MECKLENBURG COUNTY
Park and Recreation Department

MEMORANDUM

DATE: January 31, 2008

RE: Rezoning Petition # 2008-035 (PID #s 075-105-43; 075-105-30; 075-105-37;
079-044-02)

Technical Data Petition #2008-35

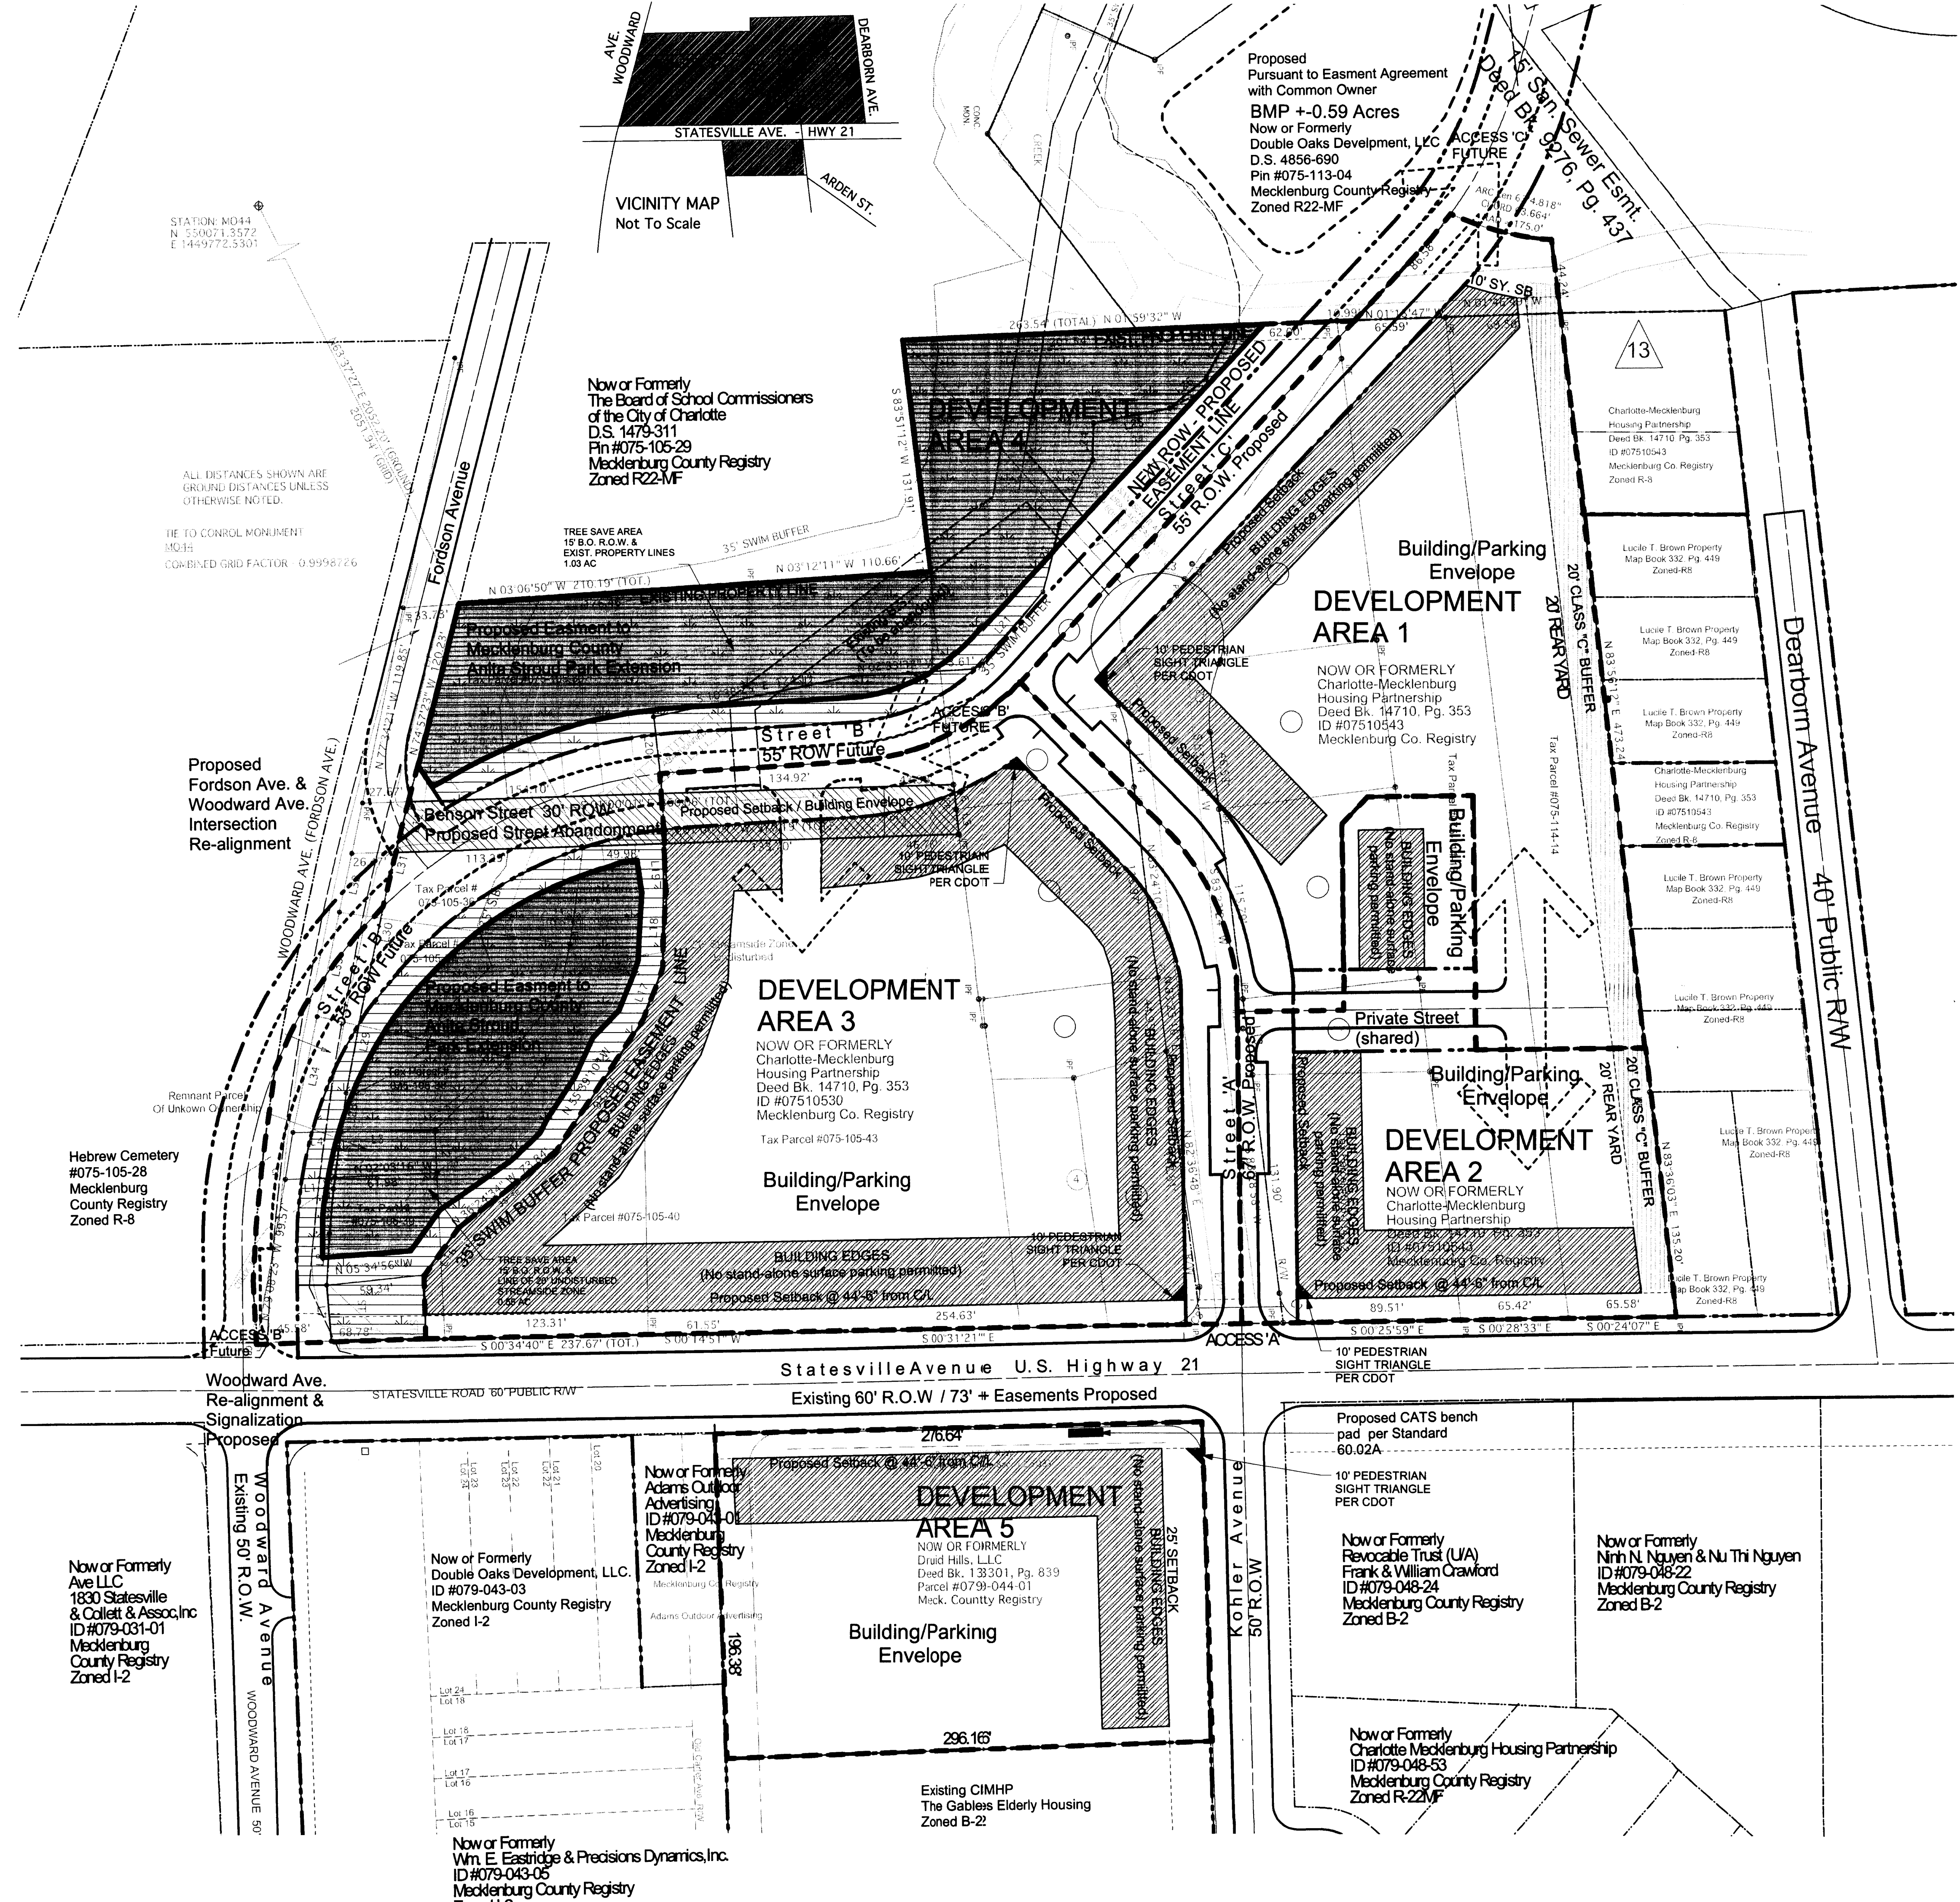
MCPR is satisfied with the proposed easement to be conveyed to the County encompassing the entire "Development Area 4" as shown on the Technical Data Plan dated 1/18/08. As referenced on note #12 on the Development Standards page, MCPR will work with the petitioner to develop a Memorandum of Agreement for the area to be conveyed to the County. However, it should be noted that MCPR will not host "stormwater management facilities/bmps and the like" on its property or easement.

Schematic Plan Petition #2008-35

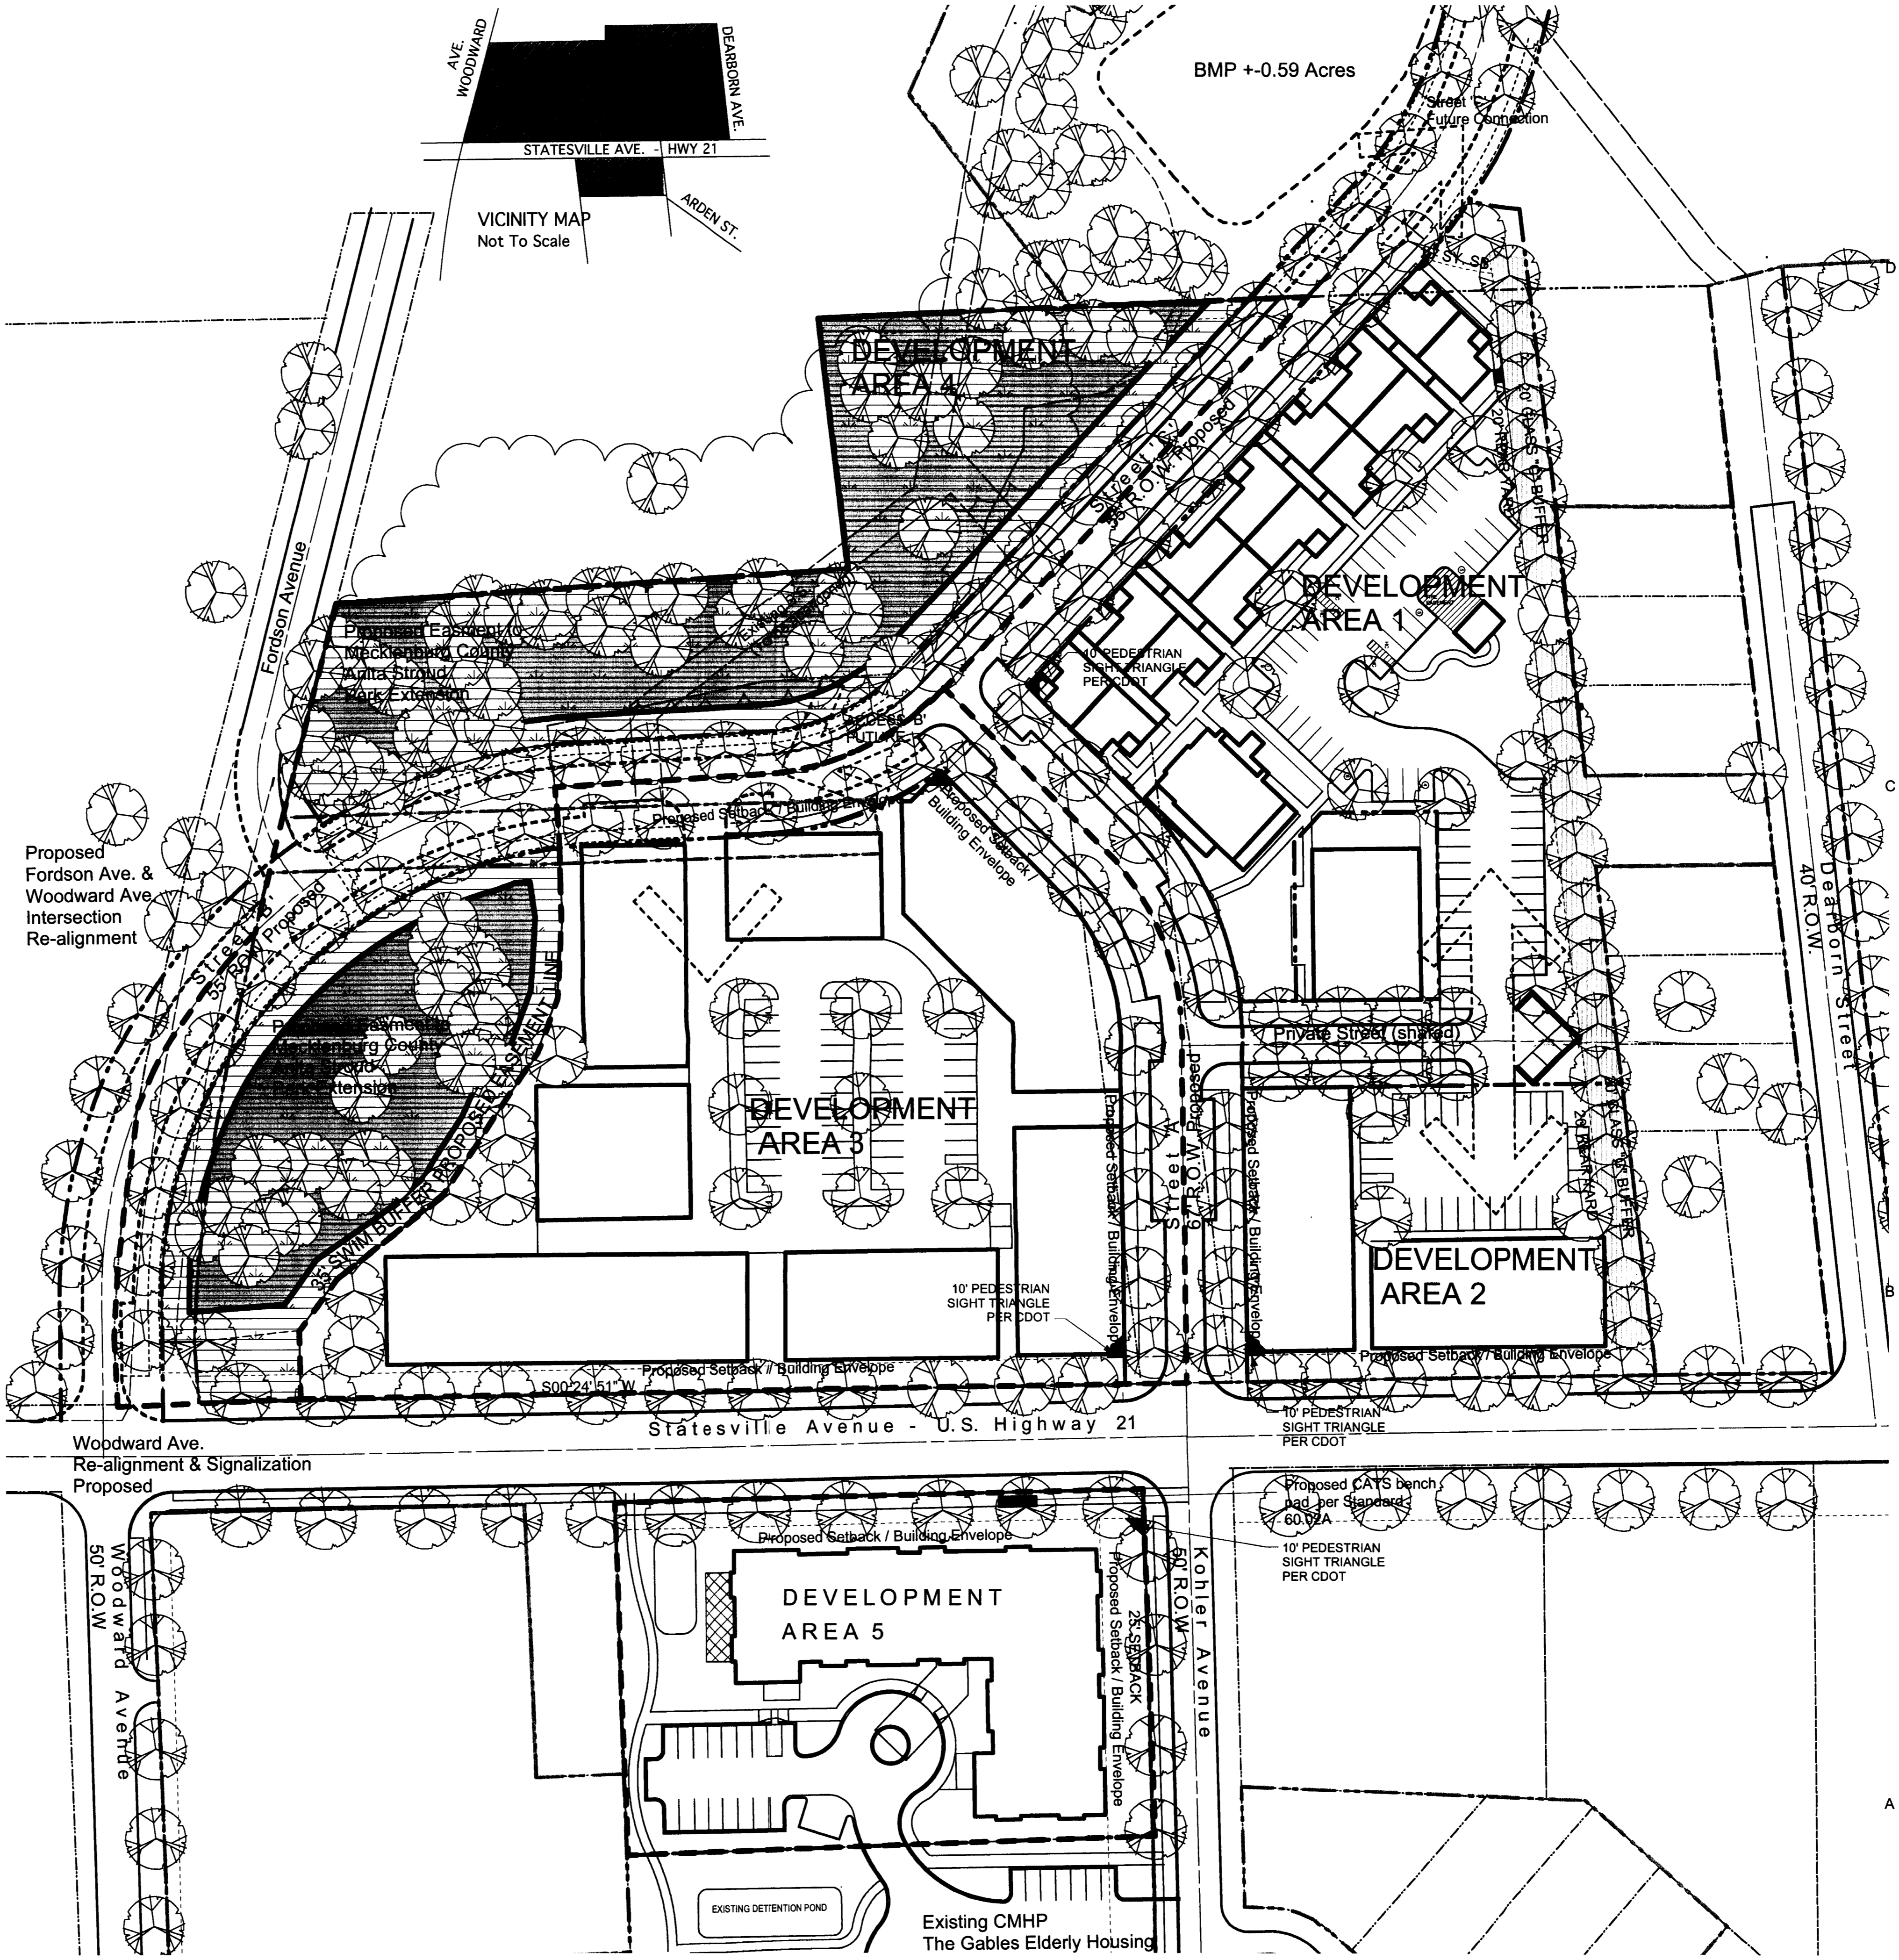
will be required to connect the proposed easements to Anita Stroud Park. This approximately 200' gap exists north of the area entitled "Development Area 4" and adjacent to the proposed BMP as shown on the Schematic Plan dated 1/18/08.
